Comments on the Applicant's Responses to Deadline 4 Submissions [part 11 – Response to Mr Moore and Dr Moore]

Unique Reference Number: 20040614

In their Section 2, which actually does relate to me, Tritax have responded to my document "Response to the Examining Authority's Written Questions and Request for Information ExQ1 Question 1.8.18 regarding the Applicant's methodology for noise assessment in the proposed Hinckley National Rail freight Interchange." of the 9th January 2024 (Deadline 4).

00:00 on 25/04/2021 to 00:00 on 26/04/2021

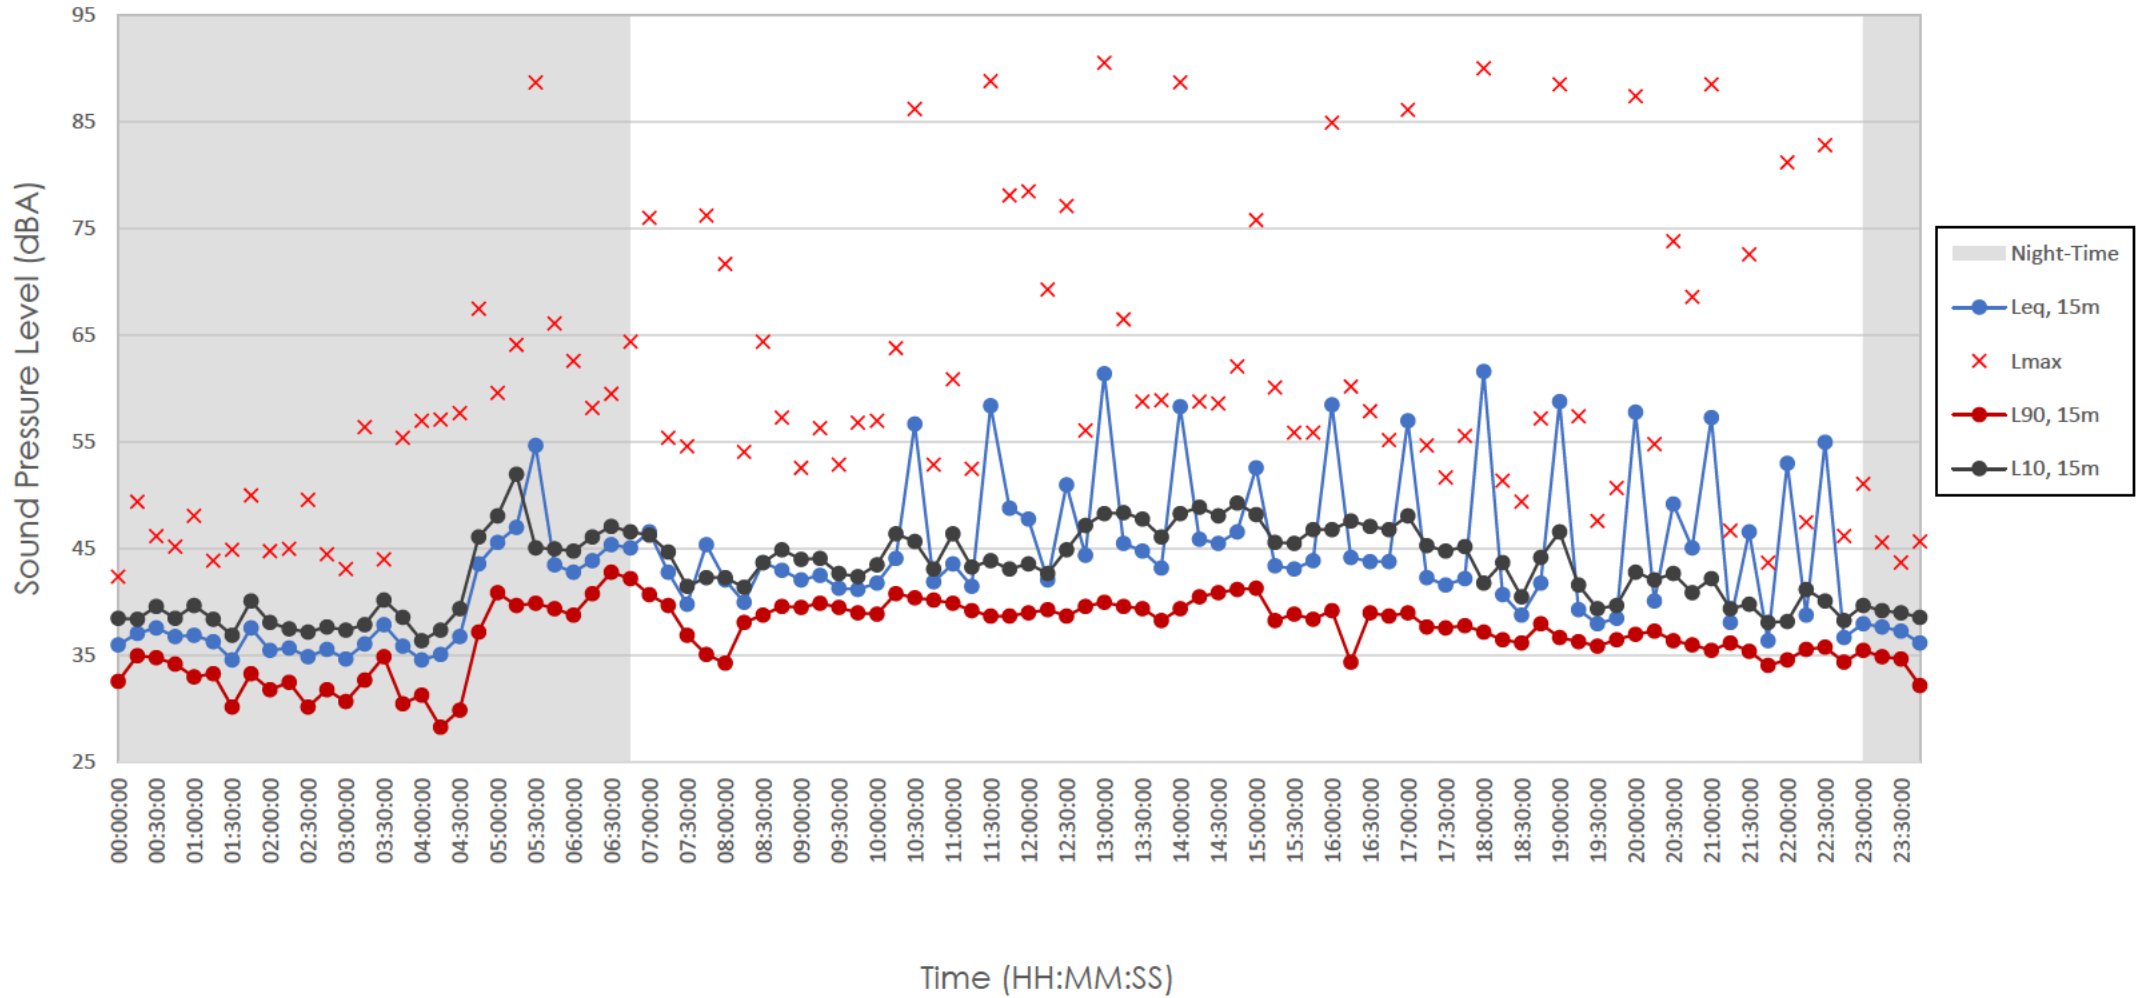
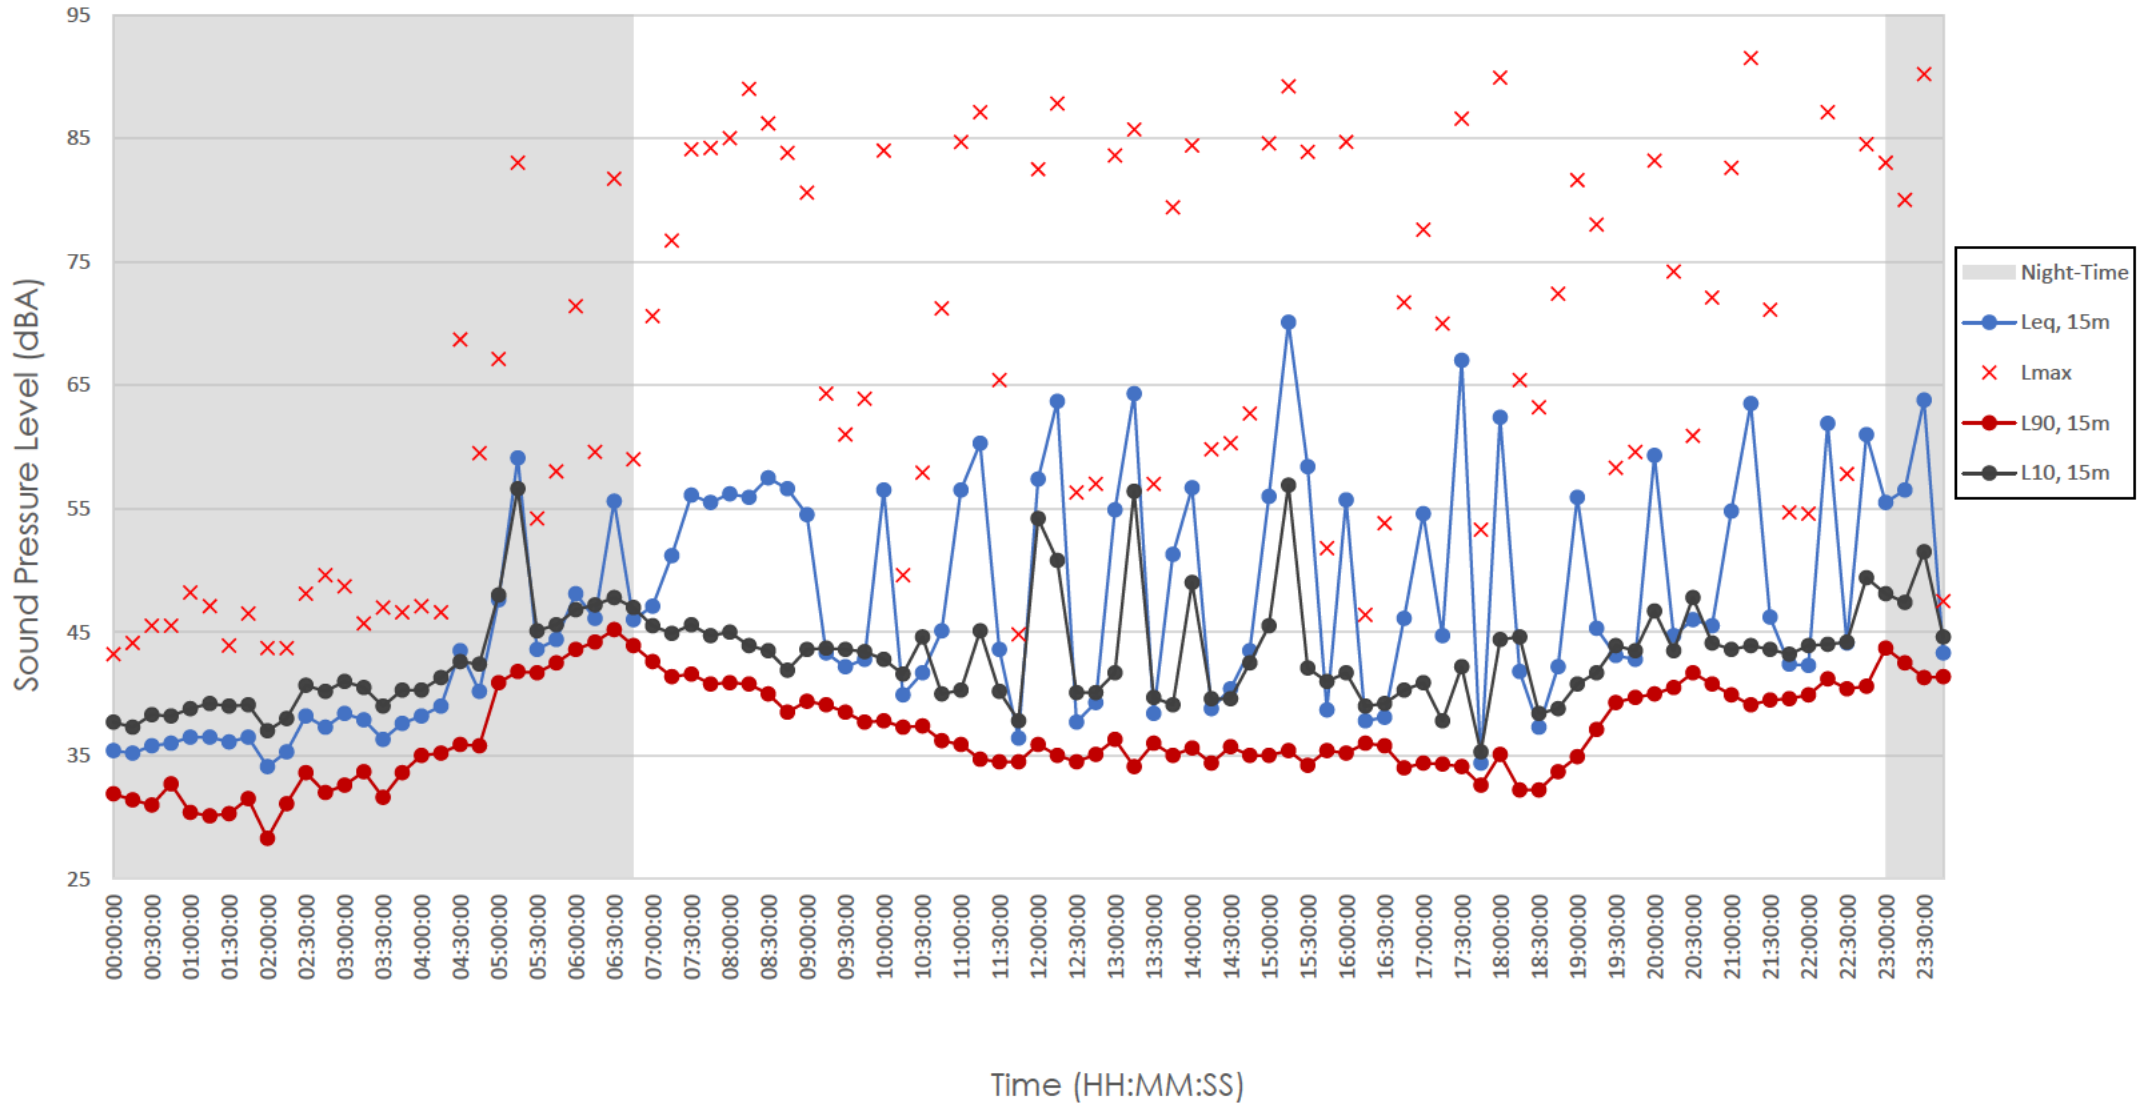
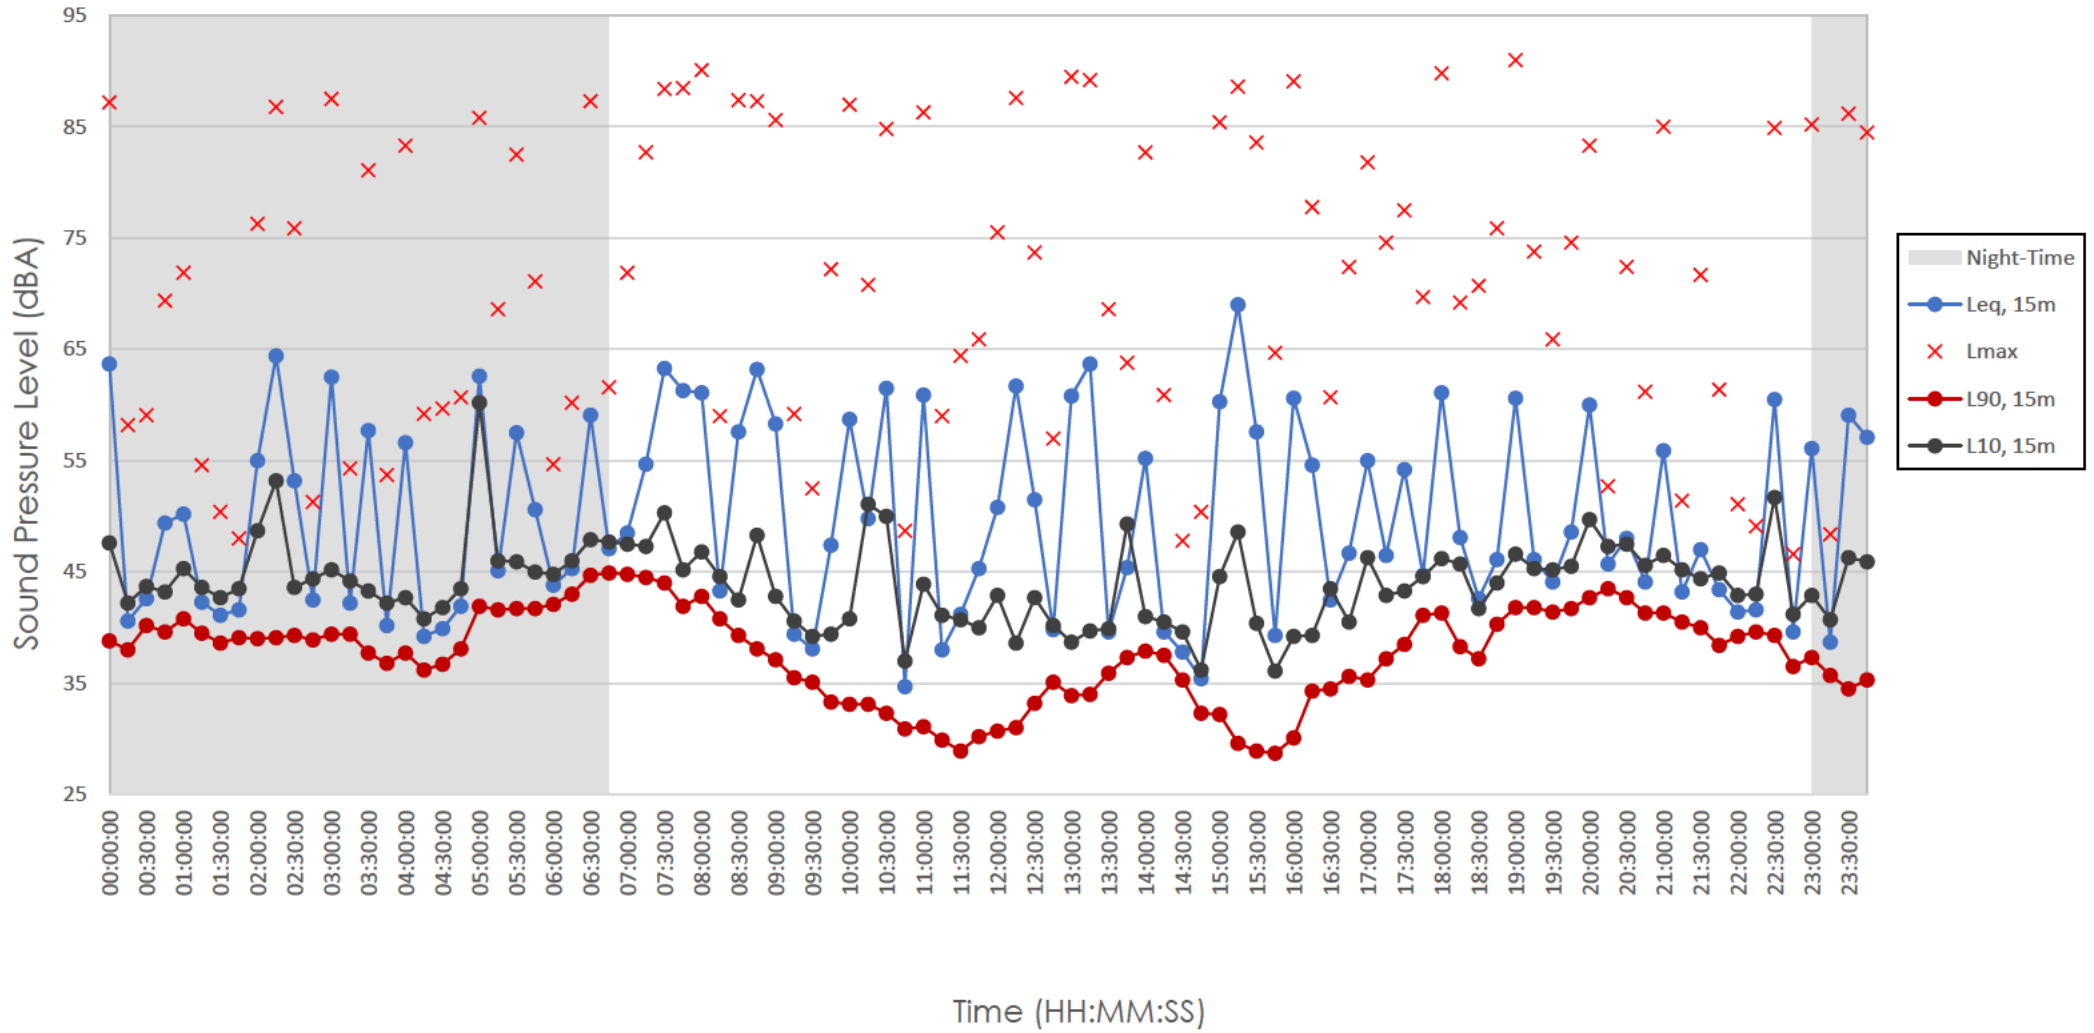
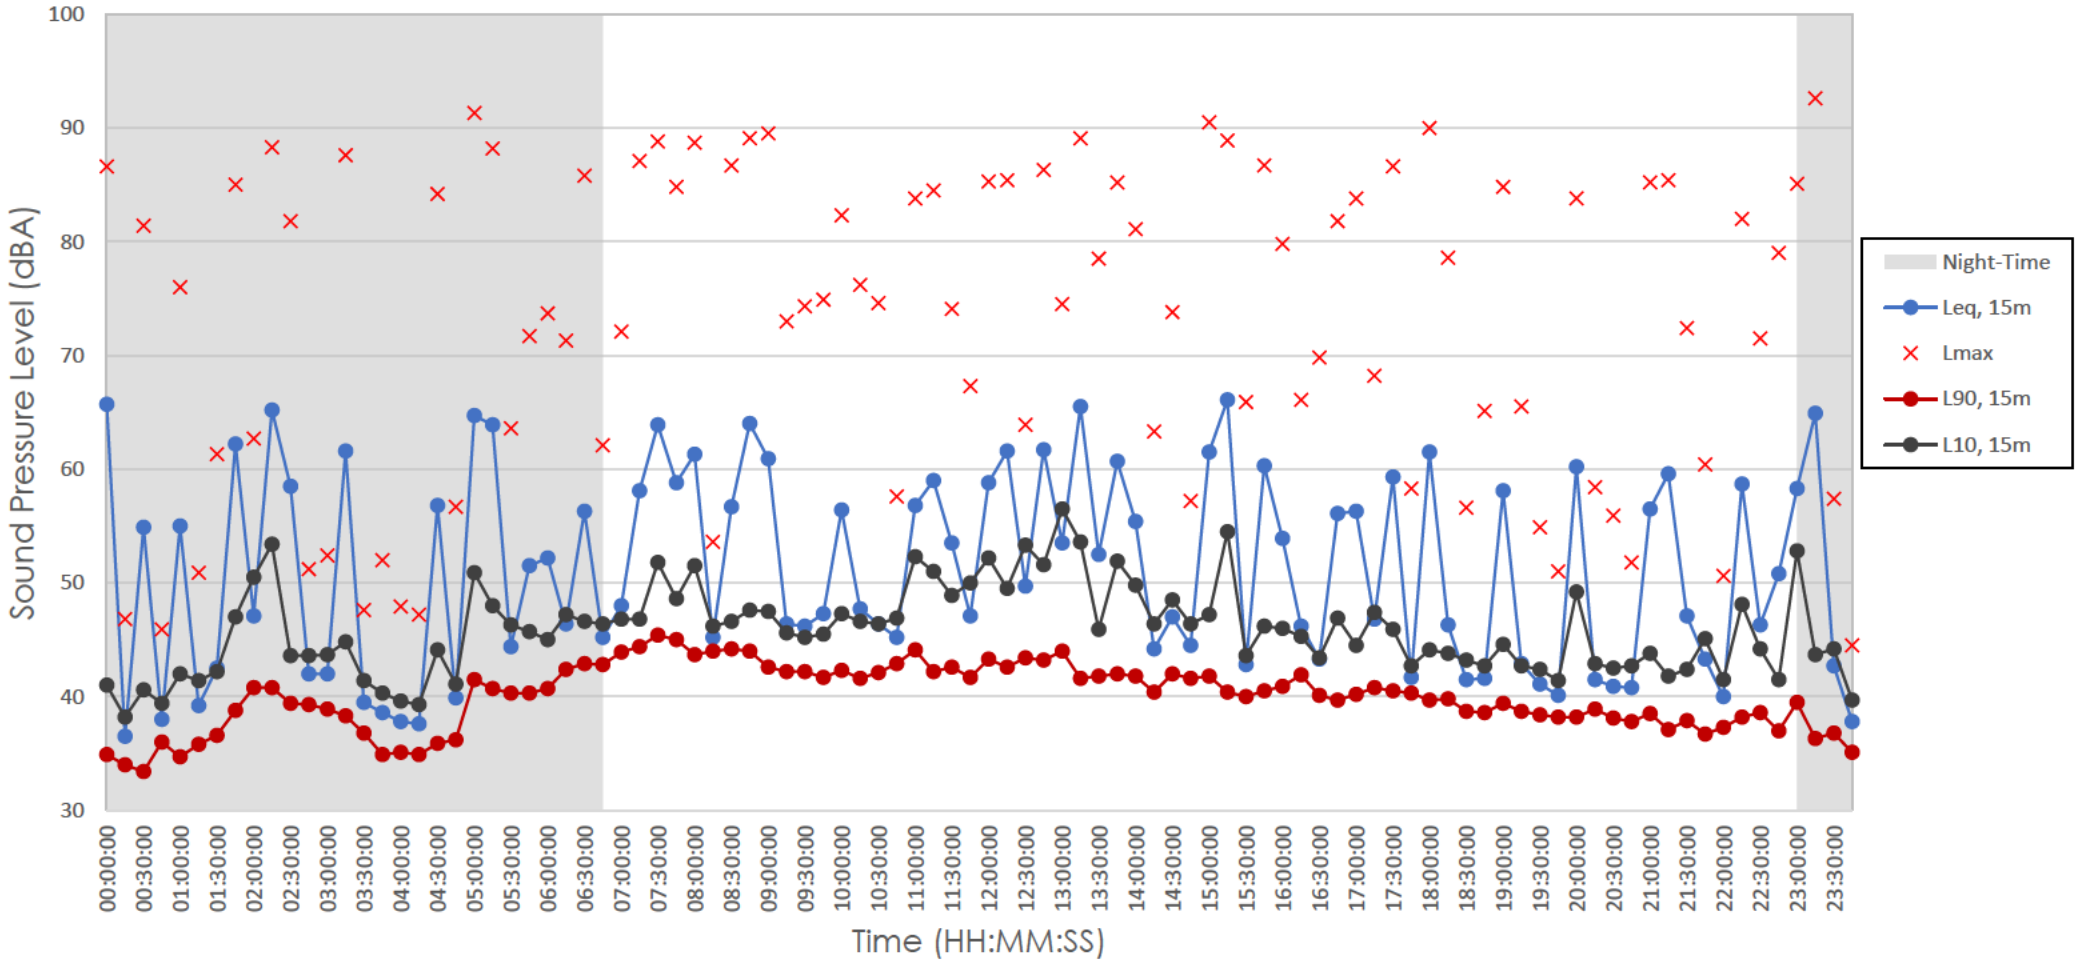
Moreover, the noise levels Tritax measured at the trackside and indicated in graphical form in Tritax’s ES Appendix 10.10 “Summary Results” are entirely in line with the train passby characteristics that I have indicated.

Tritax’s statement is incorrect, as I shall explain. The noise levels measured at the trackside over the 7-day period are continuous along the length of the line that is considered here, **and no rail noise maps are required**. Further, the DEFRA rail noise maps that Tritax have sought to introduce are intended for use only at a strategic level and are very much higher (12dB to 15dB) than the noise levels that Tritax measured at the trackside at NMP3 and NMP4 over the 7-day period and then used as a foundation of their Noise and vibration report.

Moreover, the DEFRA rail noise maps give no indication of the noise levels at Weekend daytimes or Weekend night-times, and indeed are so broad-brush that they indicate a **higher** rail noise level at night-time than daytime. In contrast, the noise levels Tritax measured at the trackside over the 7-day period give detailed information for both Weekends and Weekdays, and both daytime and night-time.
